February 27, 2001

RE: Shops @25(F17-D46A) - Drainage Re submittal

**RE: Drainage Report for Shops @ 25**  
**Plan dated January 18, 2001**  
**Drainage File # F17/D46A Tract I**  
**Request for Site Development Plan for Building Permit, Building Permit Approval, and**  
**Grading Permit**

SHOPS @ 25 GRADING AND DRAINAGE PLAN	DRAWN BY JDN DATE 02-26-01 2030GR3.DWG
	SHEET # 1 OF 2	JOB # 200030

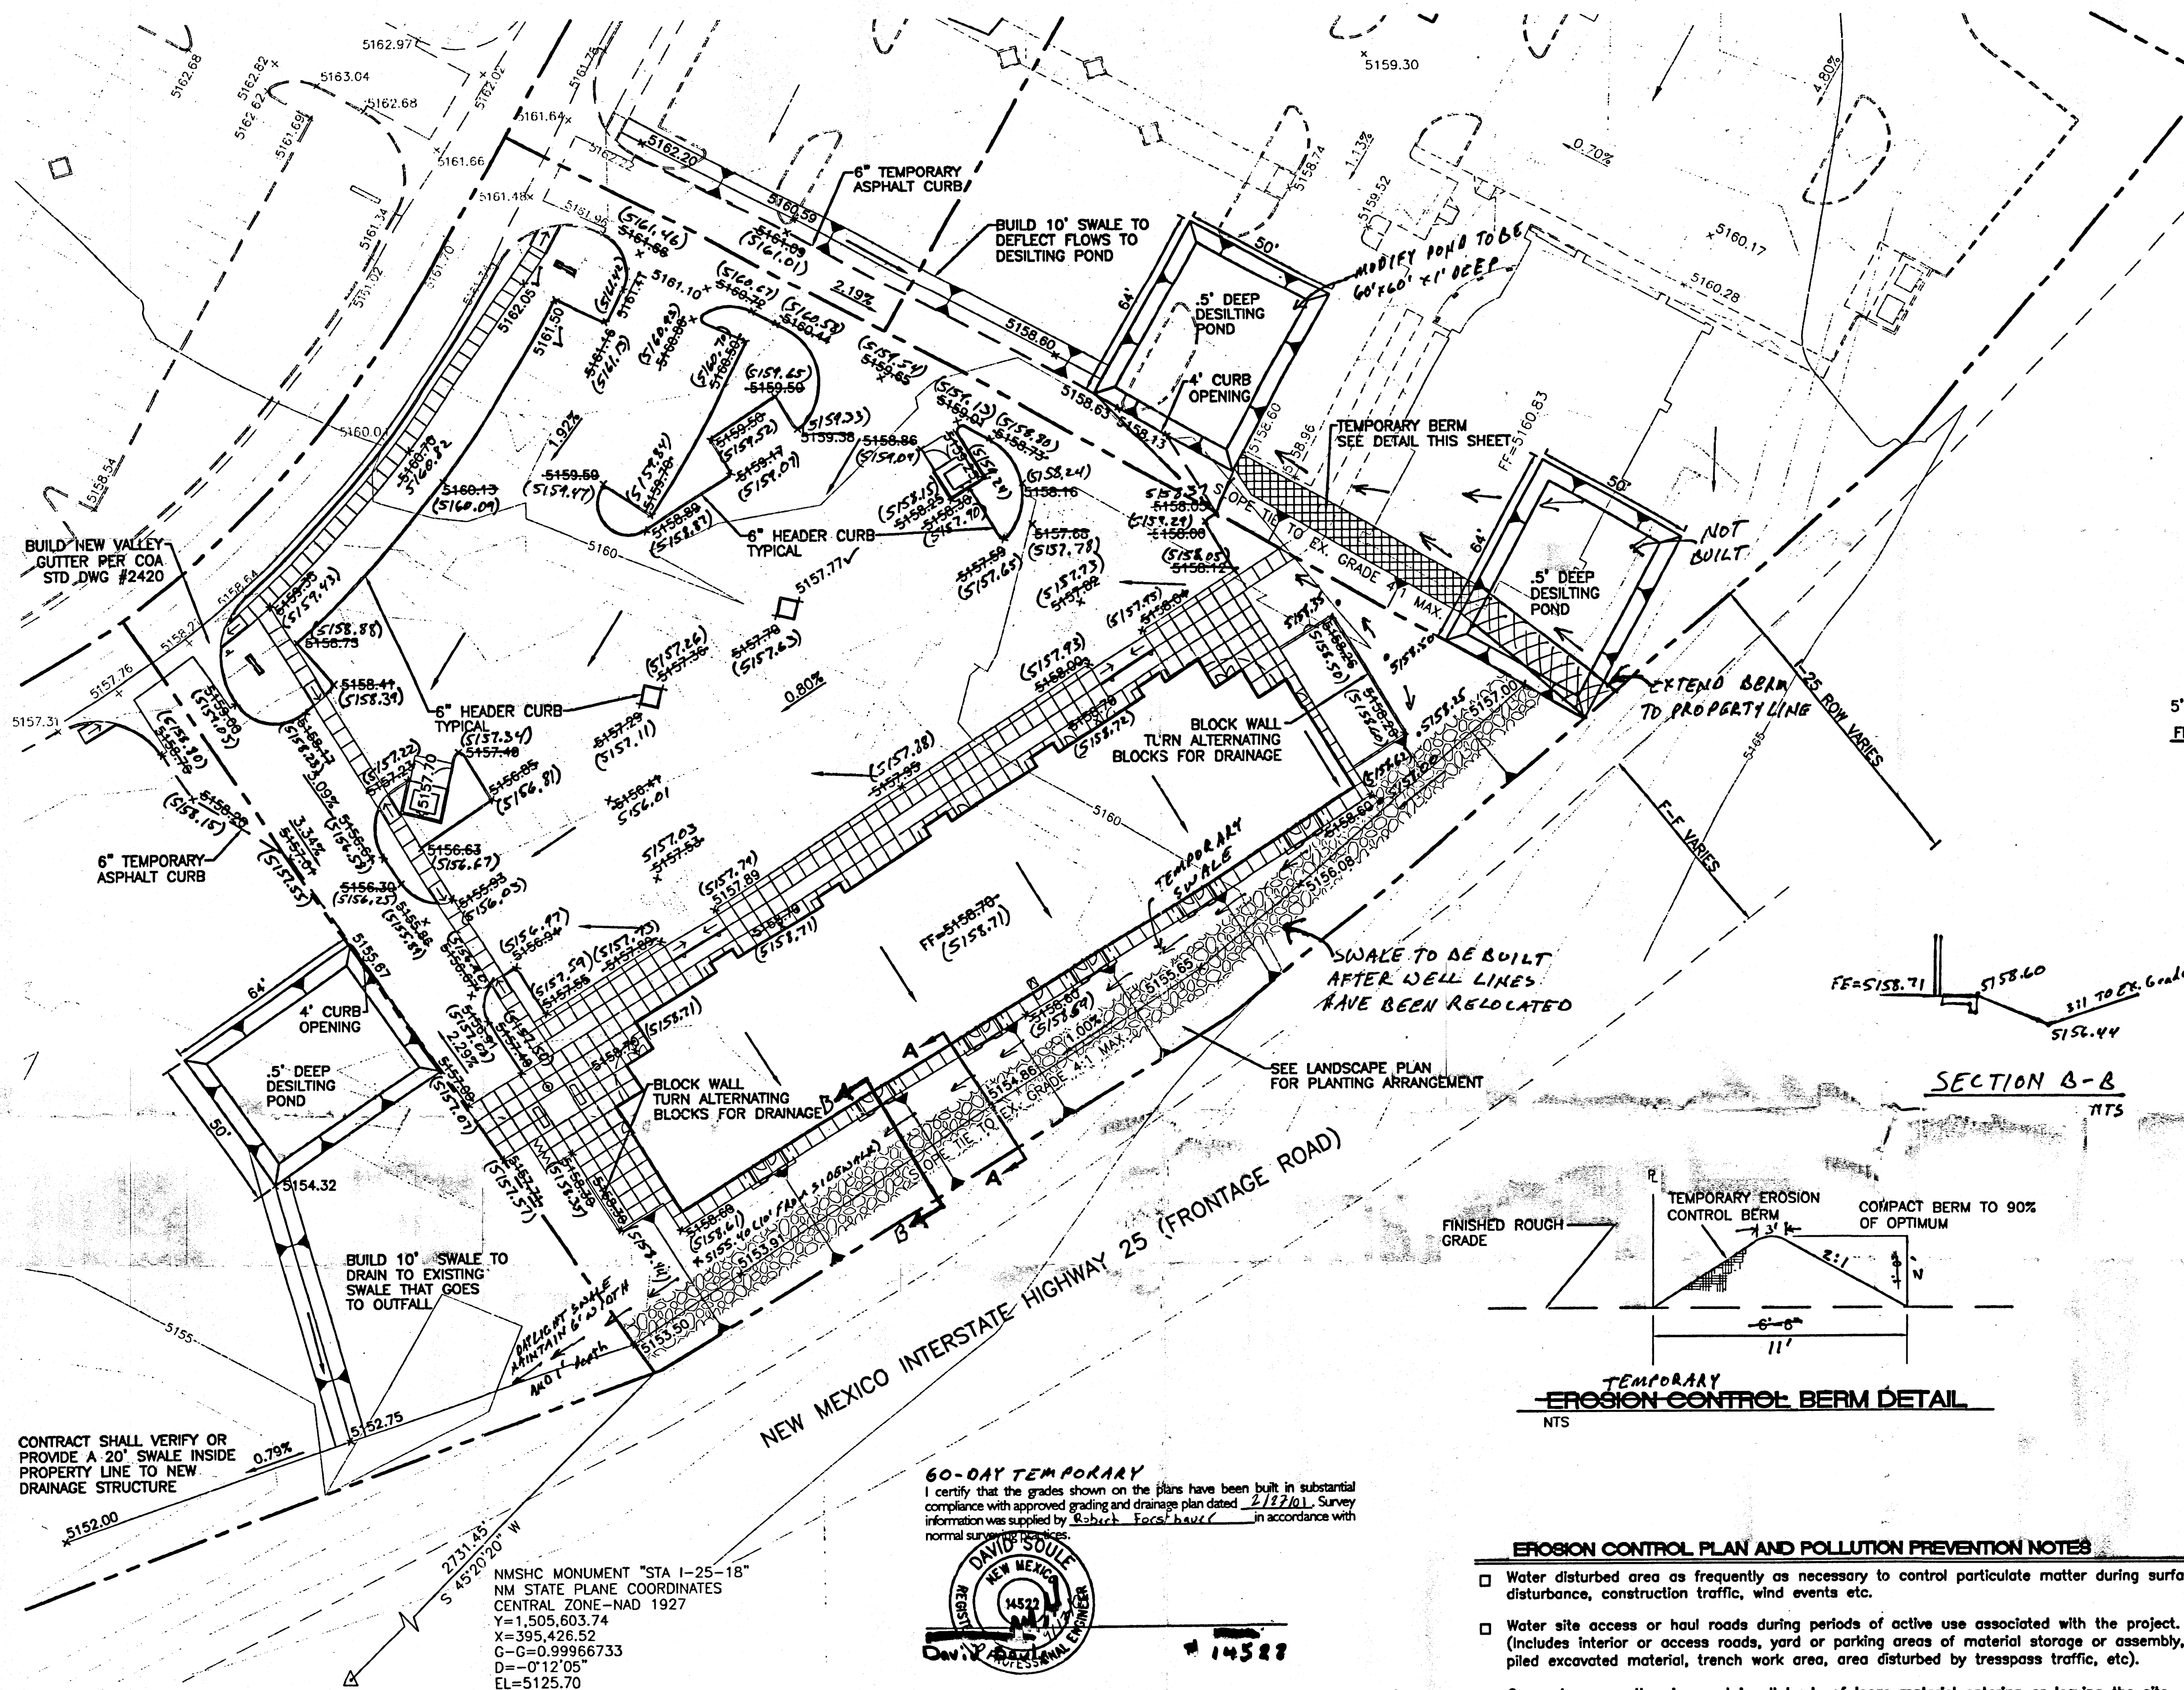
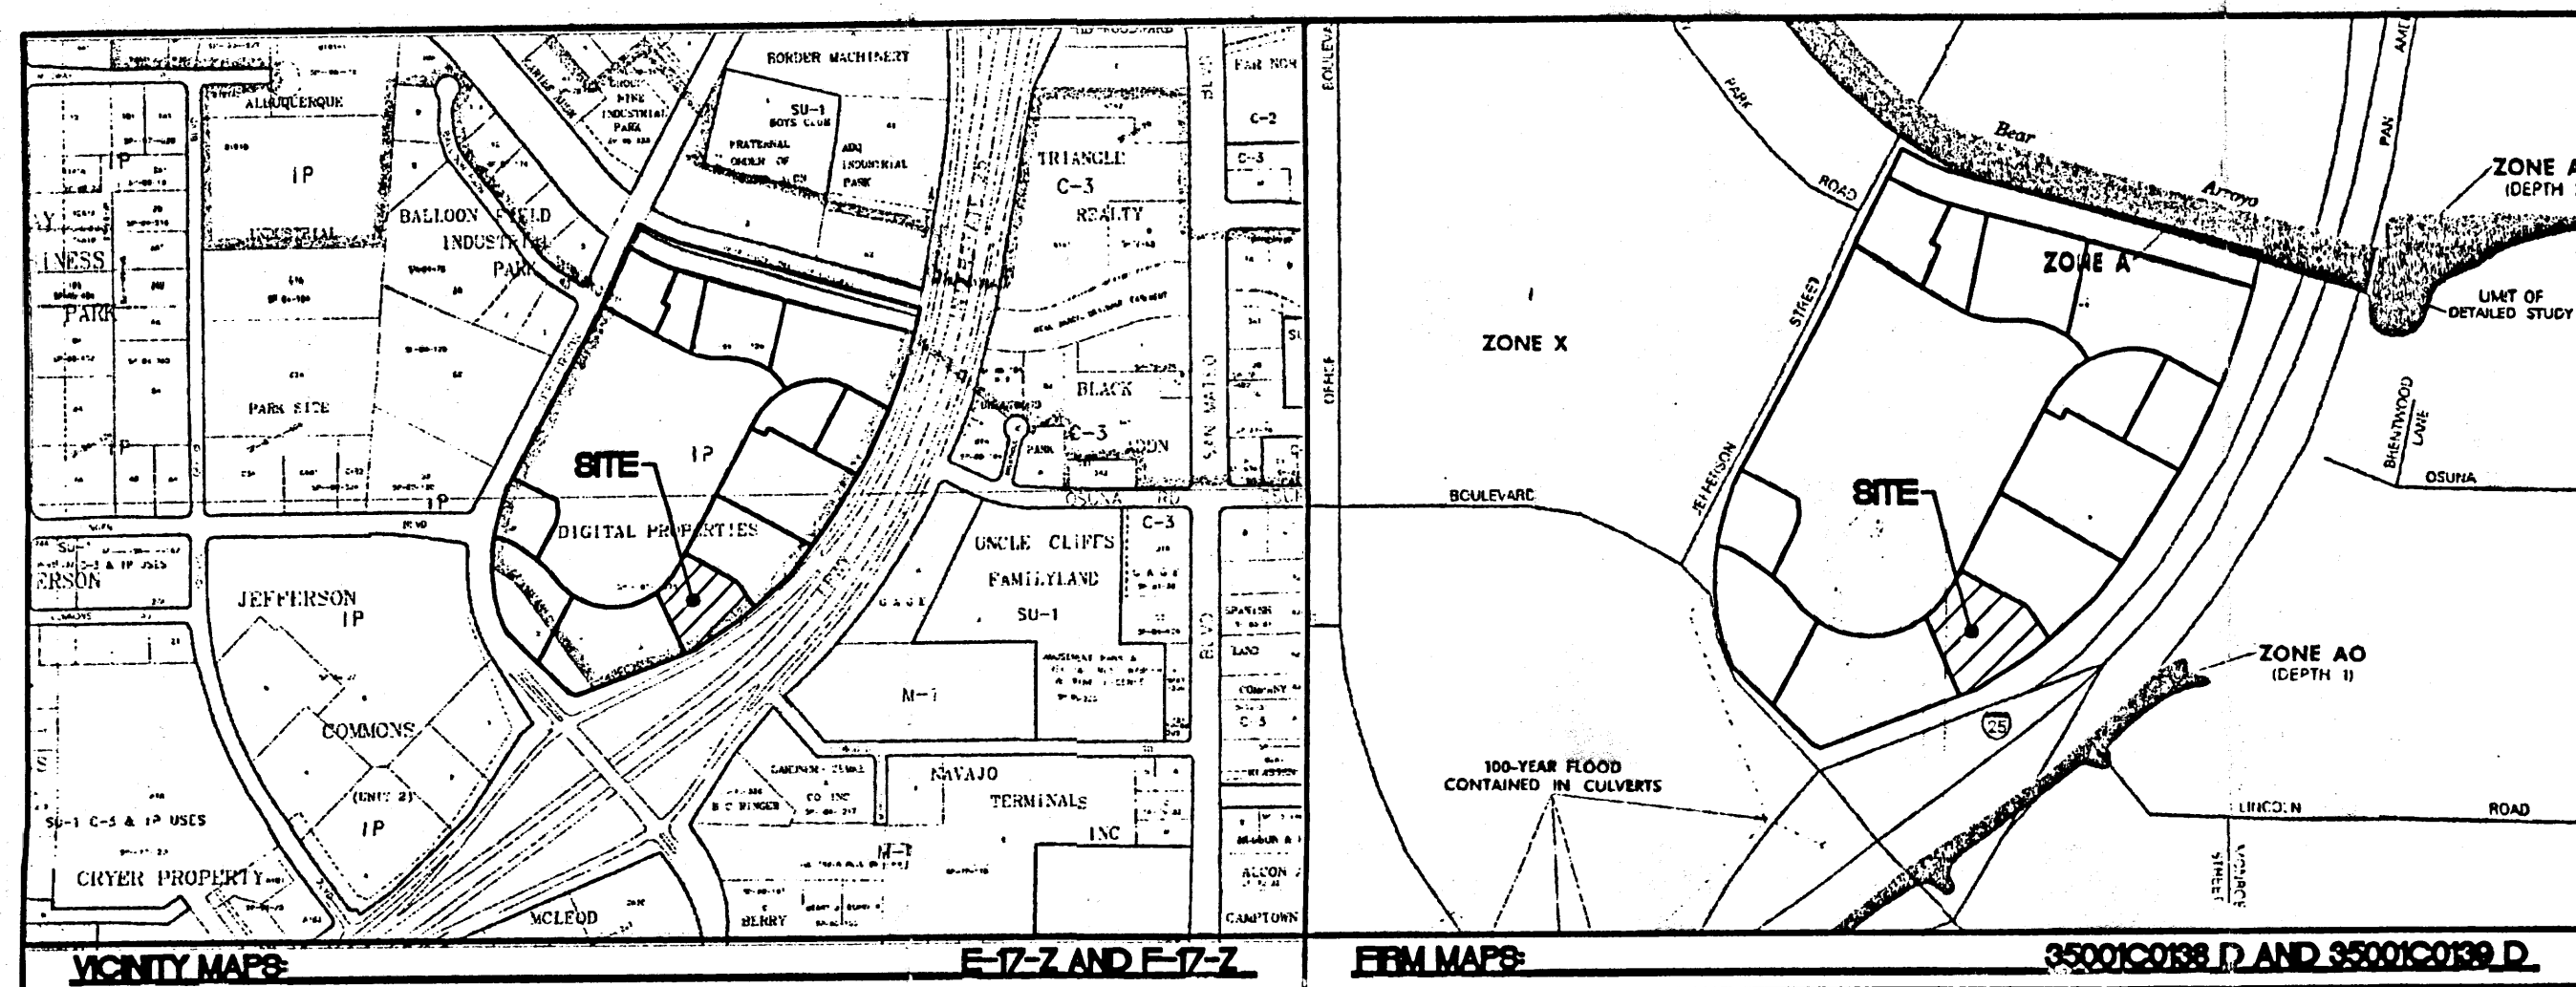
**A cross section of the existing inlets showing the new penetration has been provided on the profile sheet, sheet 2 of 2.** ✓
4. Identify the maintenance responsibilities for the private off-site desiltation ponds and riprap channel. *need*

7. Label the drainage plans 1 of 2, 2 of 2, etc  
**The numbering of the sheet was modified appropriately.**

8. Provide a signature block for our approval on the grading plan.  
**A Rough Grading Approval signature block was added to the plan.**

**The maintenance responsibility for the temporary ponds was added as note #4 on sheet 1 of 2. The maintenance responsibility for the drainage swale has been added as note #5 on the same sheet.** *coven ants.*
